# CITY OF MERCER ISLAND

## REVISION/DEFERRED SUBMITTAL FORM

GELOTTE HOMMAS DRIVDAHL  
ARCHITECTURE

Re: Itemized Revisions for Permit 1706-084

A2.4

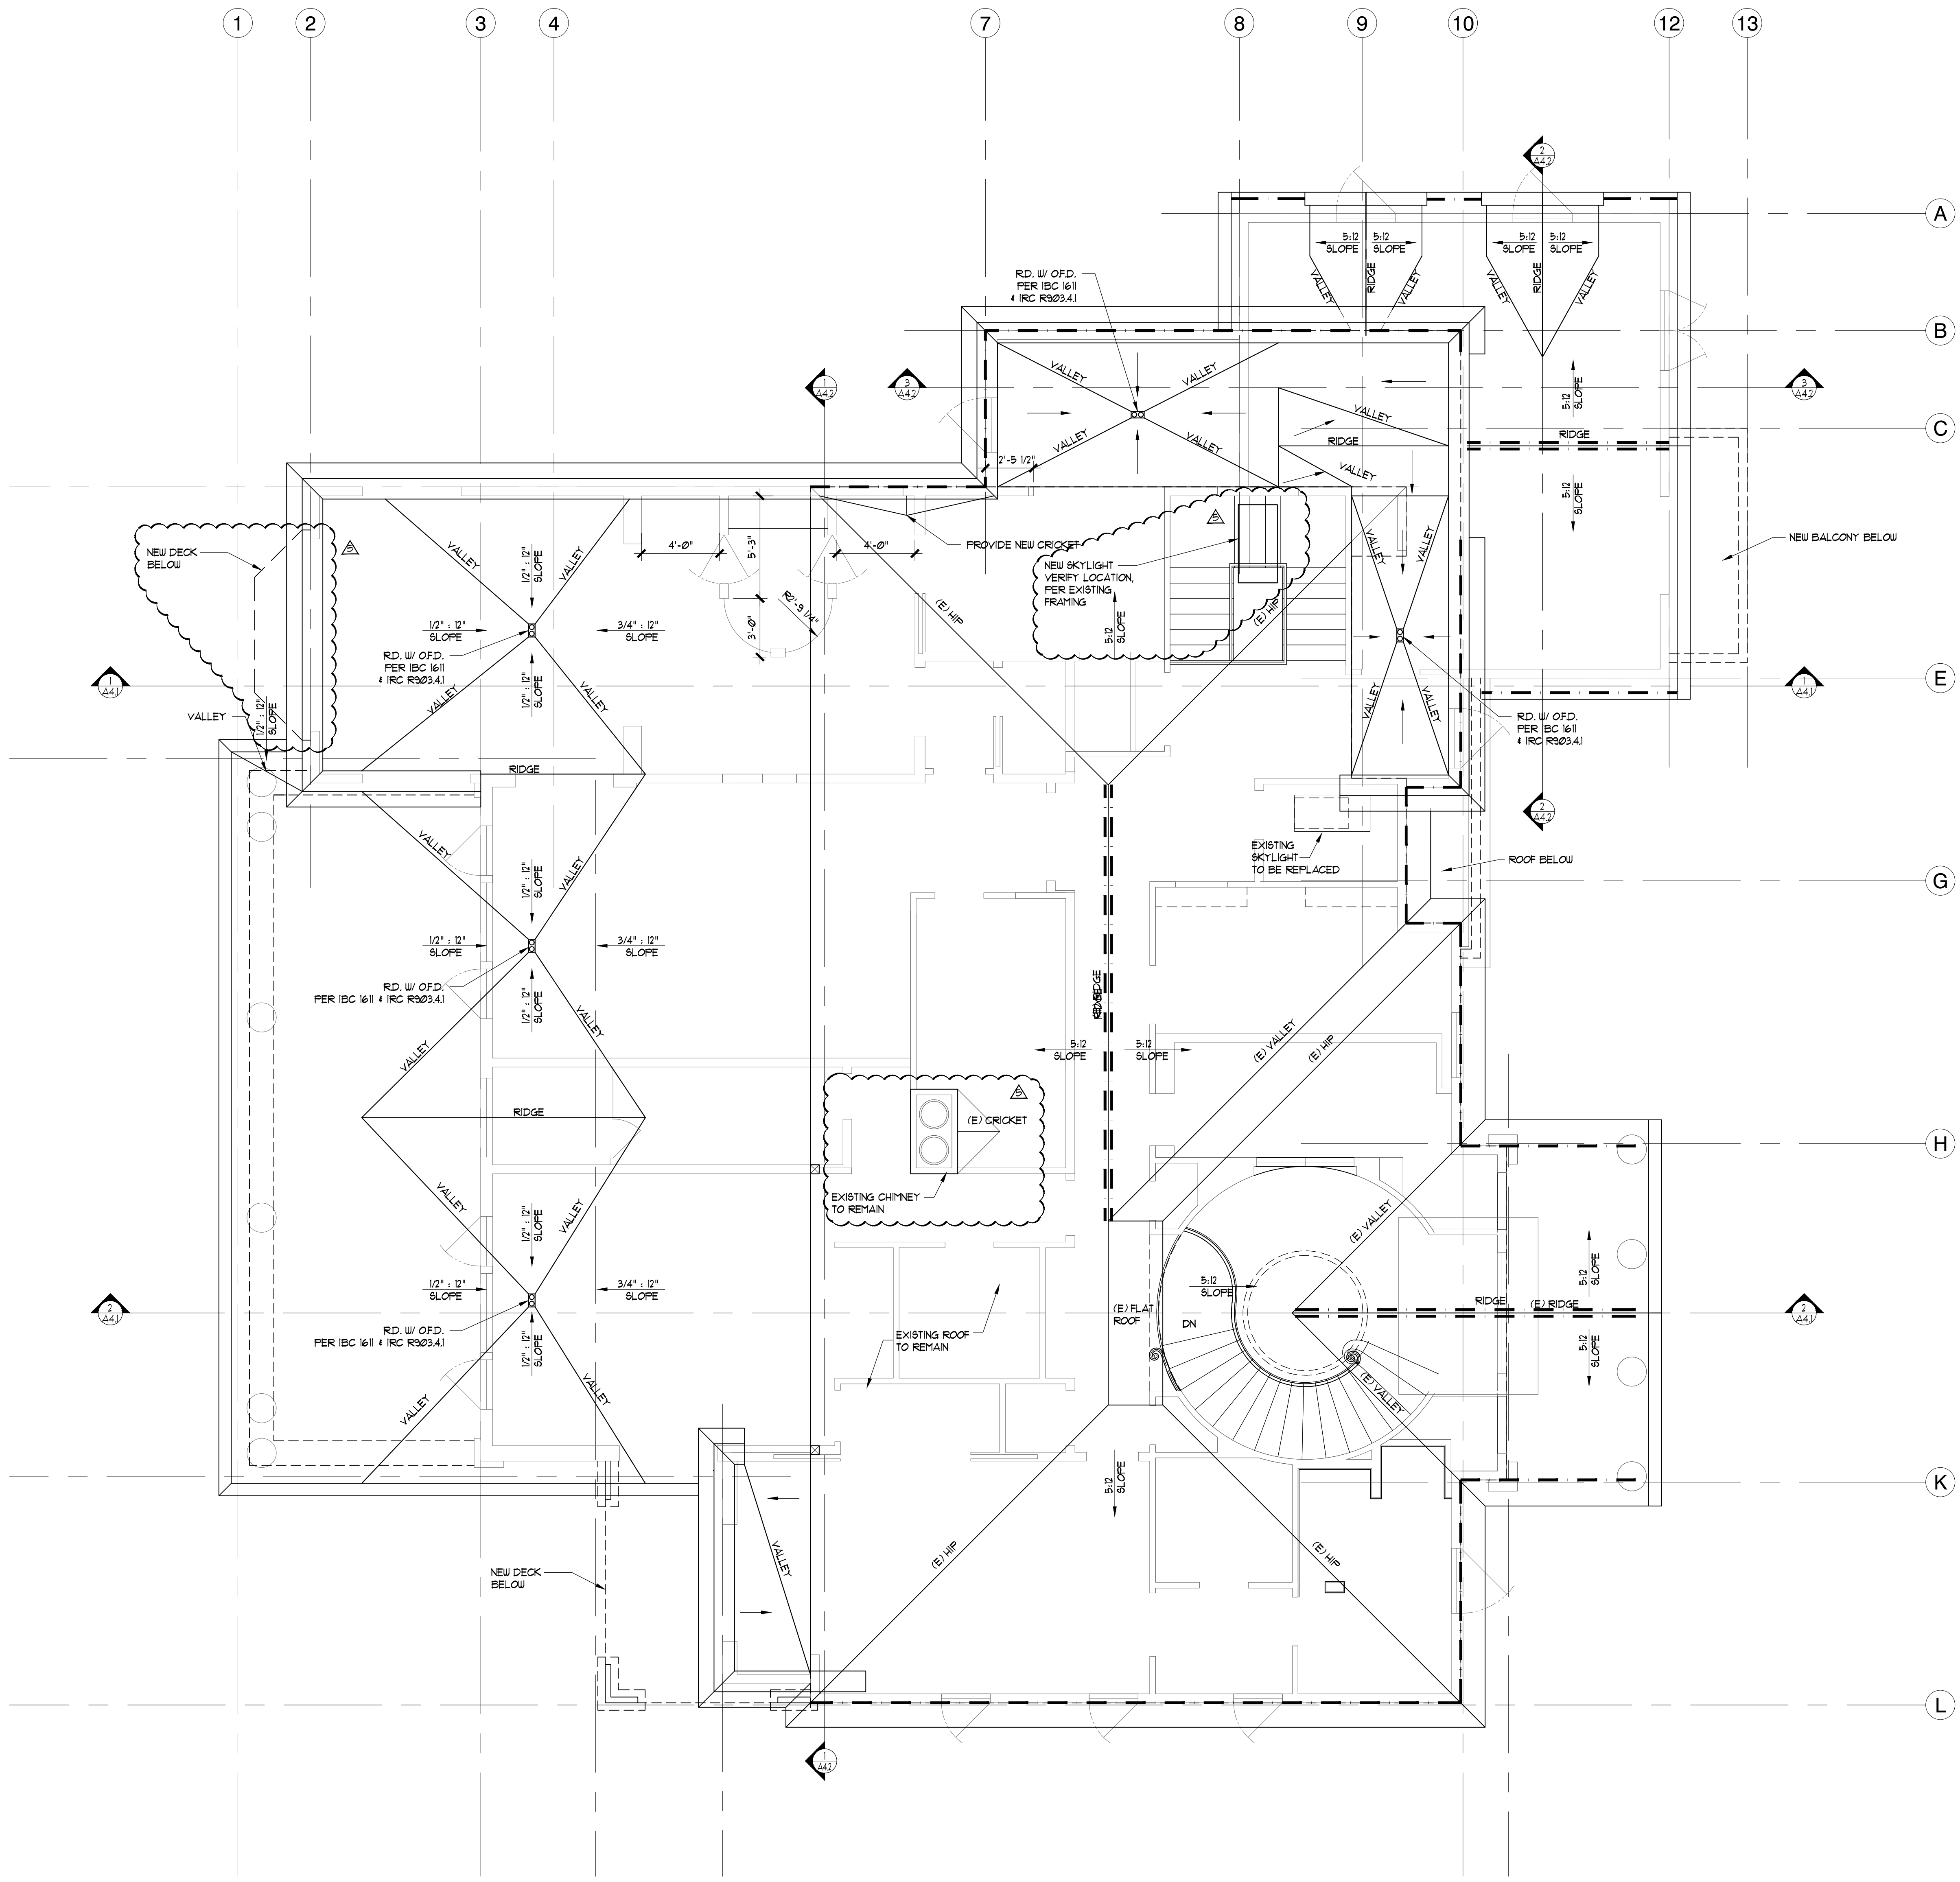
Sheet A2.4: Added skylight over north stairs  
Sheet A2.4: Reconfigured central chimney.  
Sheet A2.4: Notation for deck at Master Covered Deck added.

1 EAST ELEVATION
SCALE: 1/4" = 1'-0"

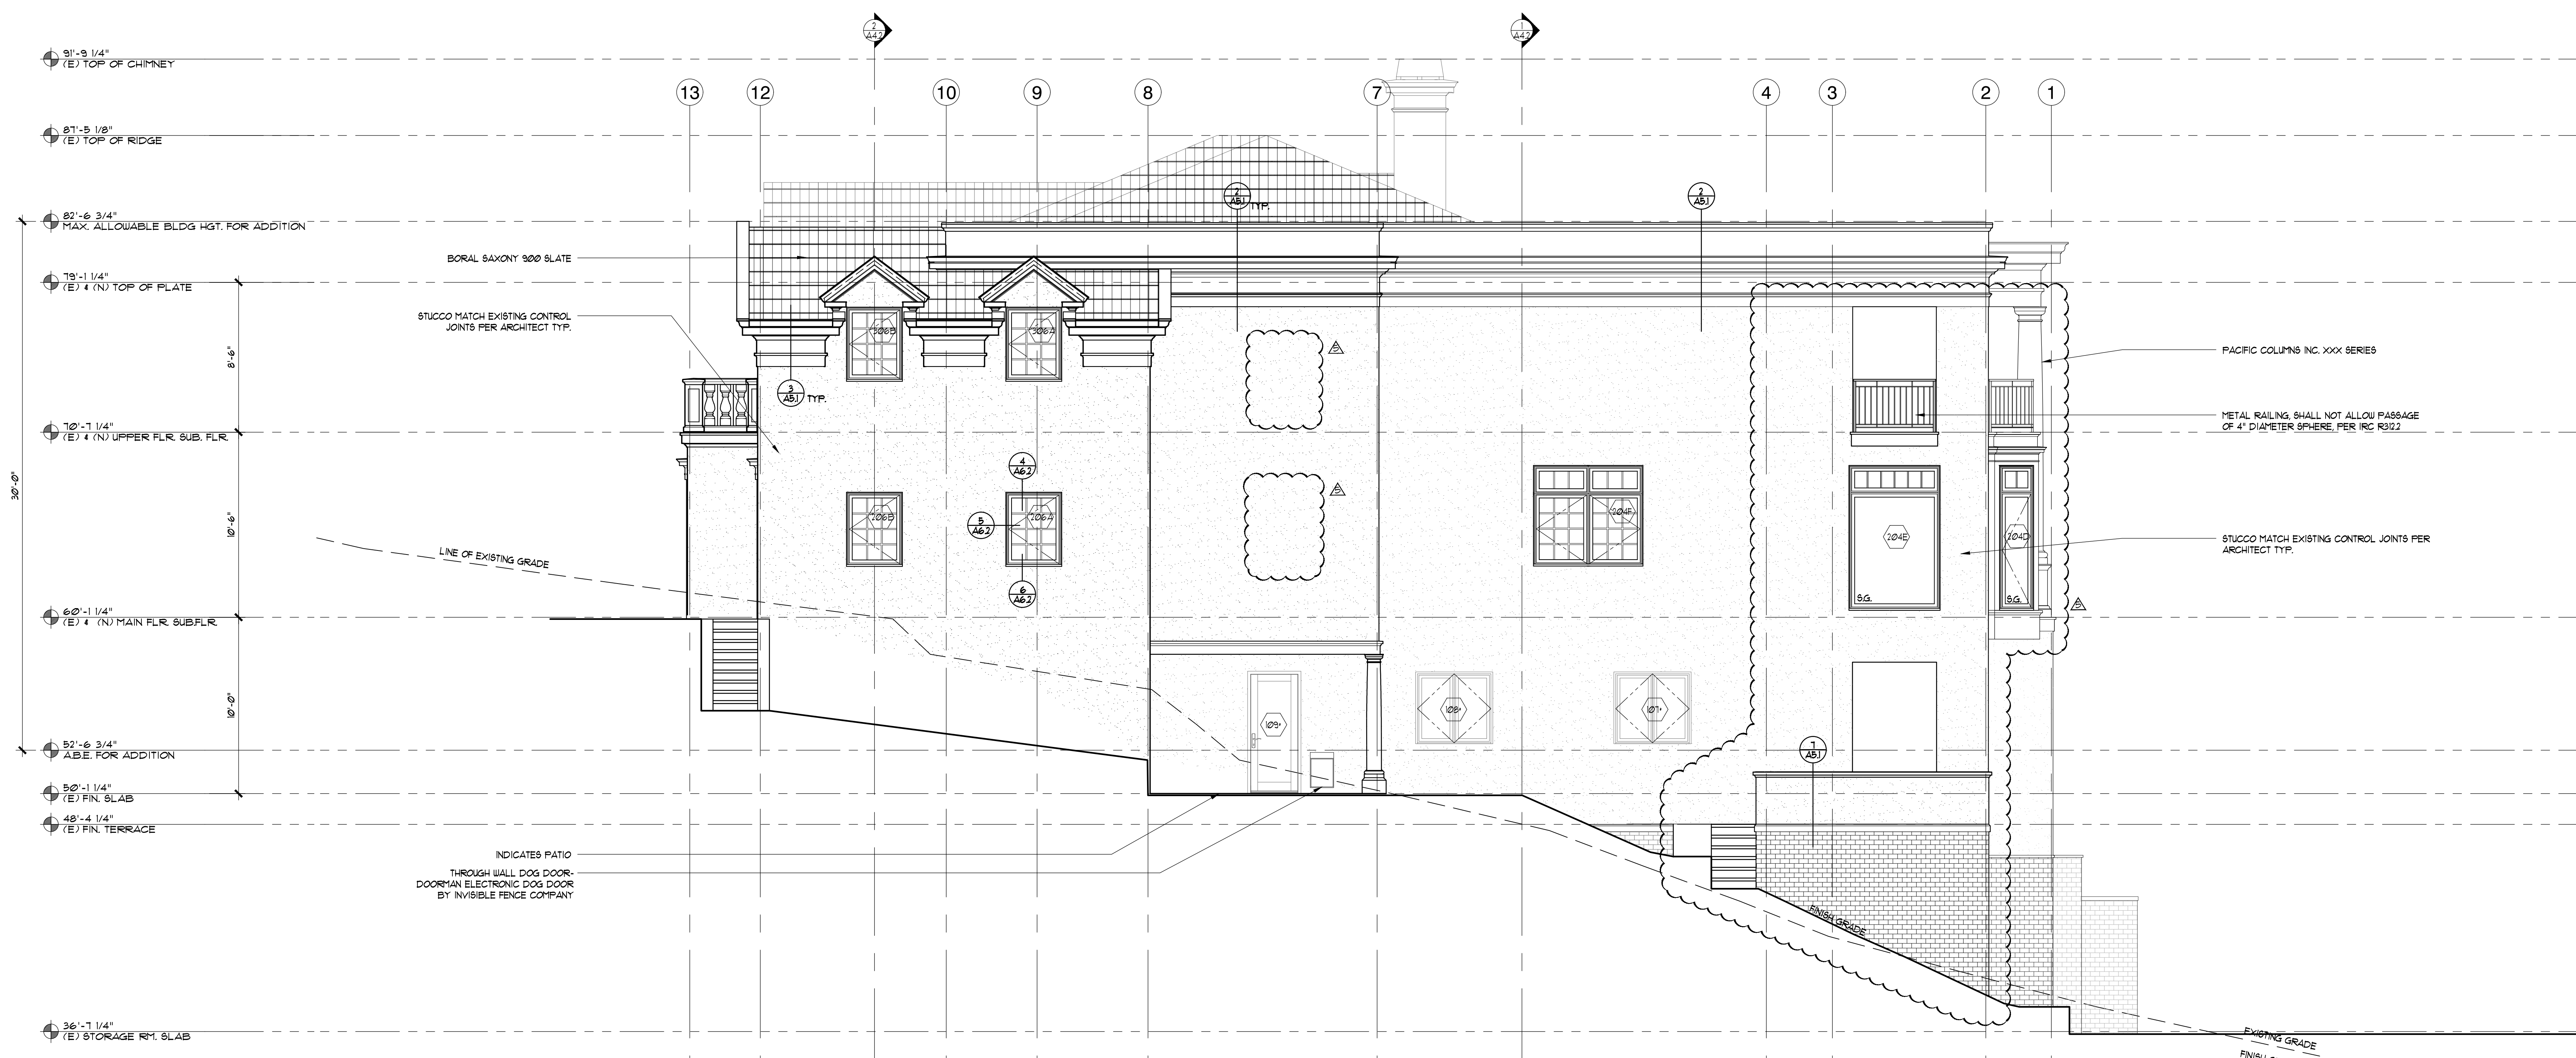
Sheet A3.1: Revised East Elevation at front entry – Reconfigured / removed windows.

Sheet A3.1: Revised North Elevation – Removed windows (between grid lines 7 & 8), revised windows, railings, openings terrace layout (between grid lines 1 & 4)

A3.1

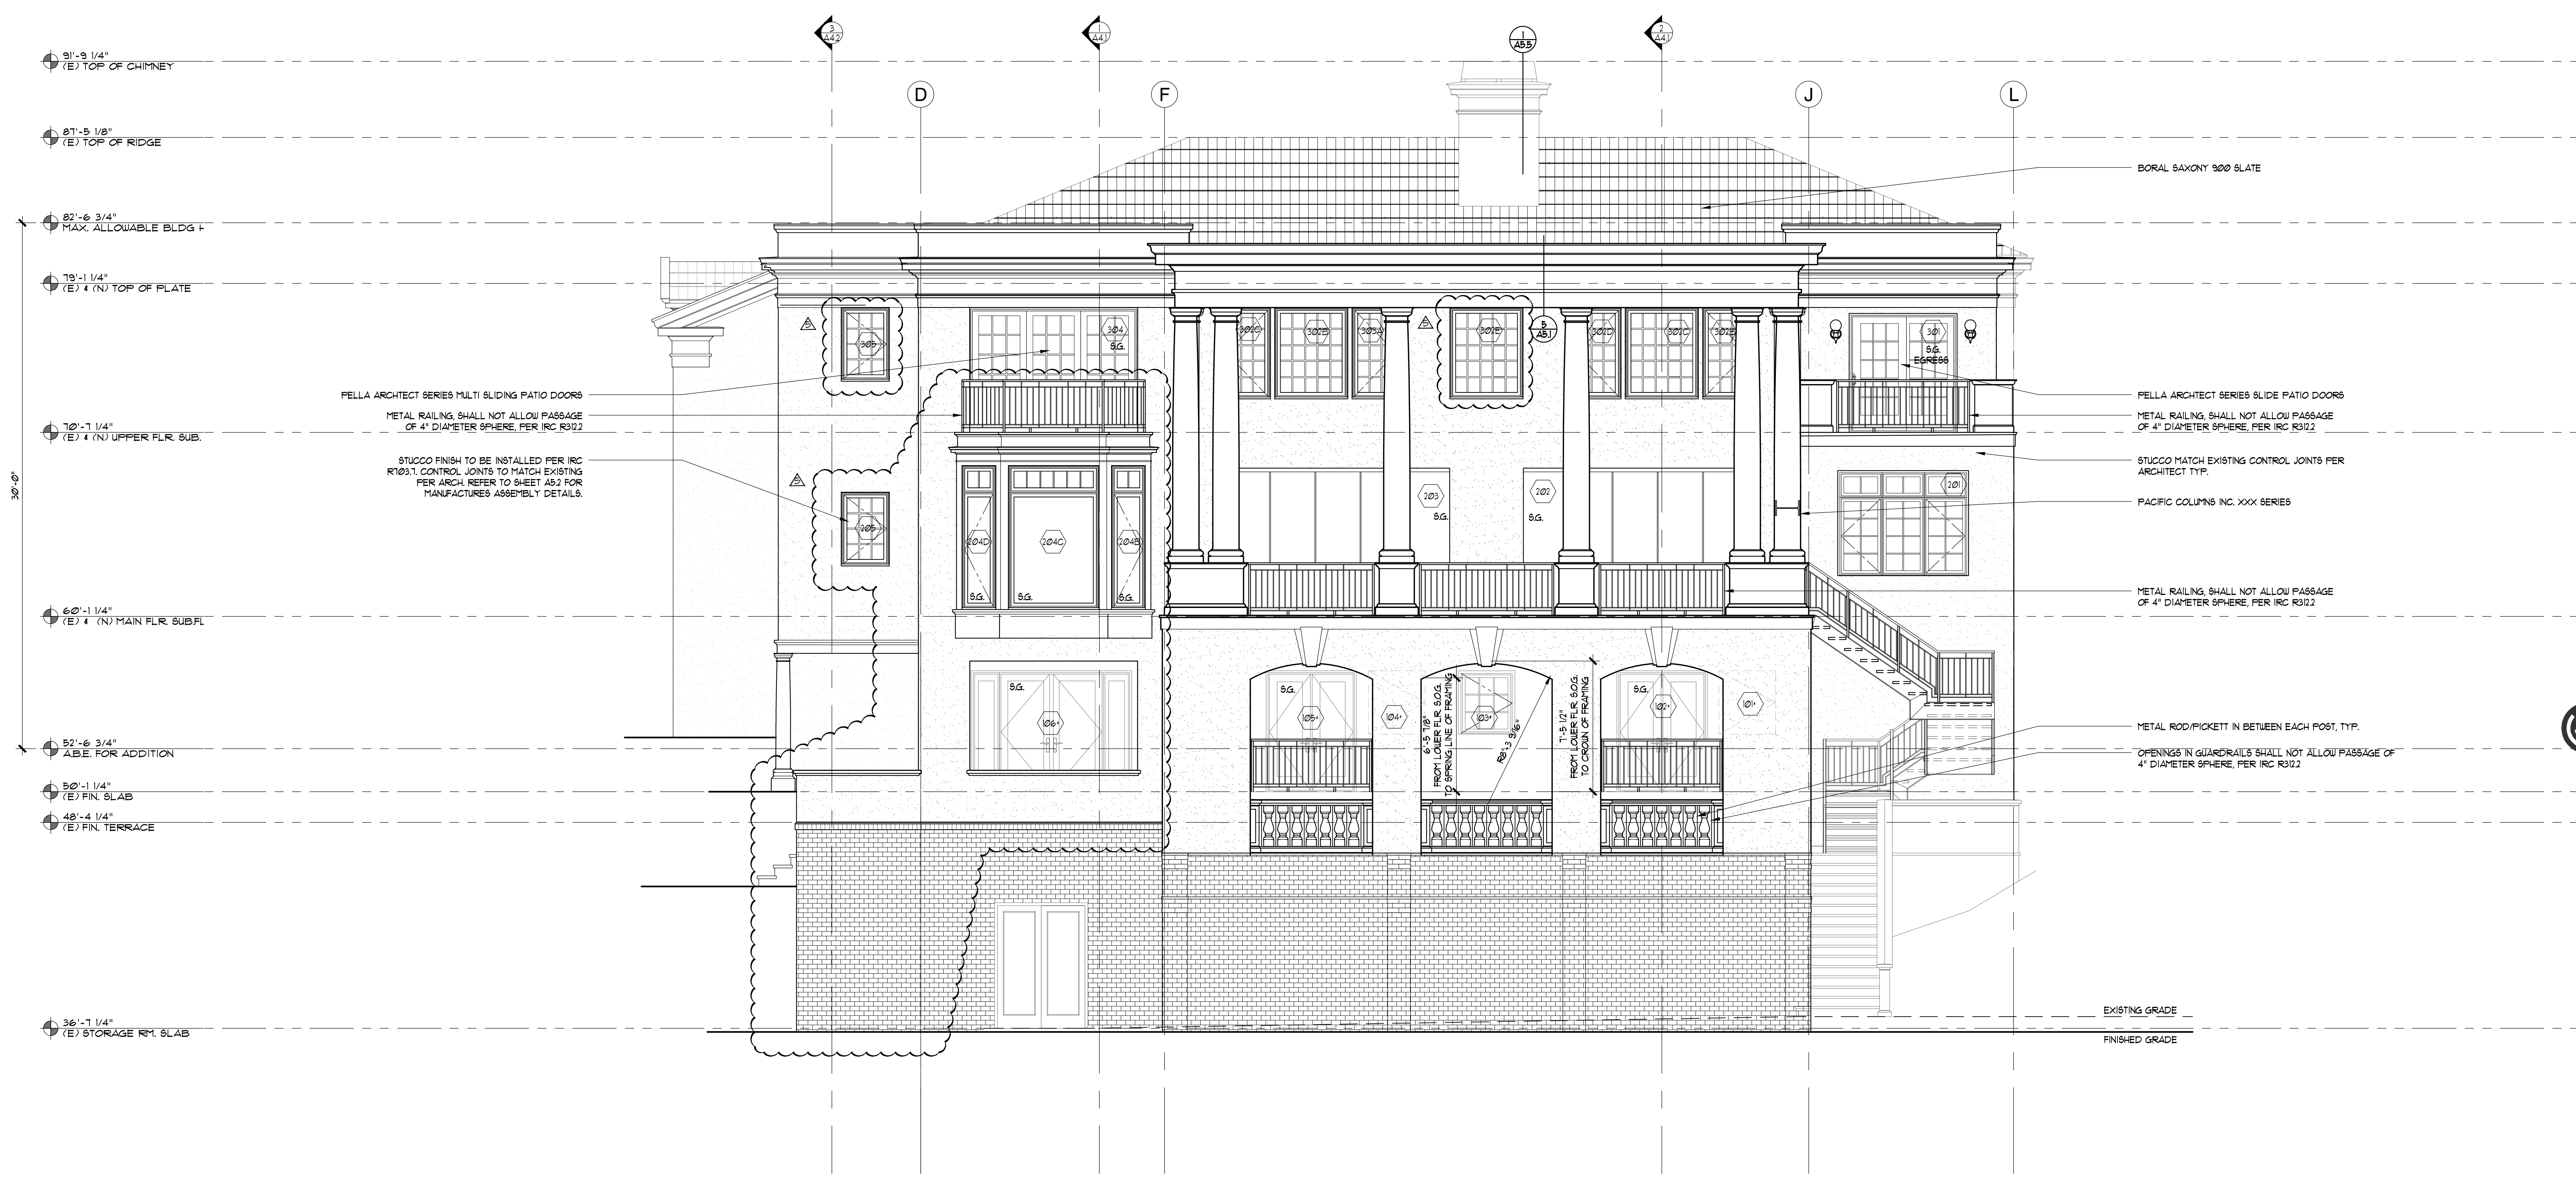
Sheet A3.2: Revised West Elevation—added windows, reconfigured lower floor patio / Nook / Master Covered Deck.
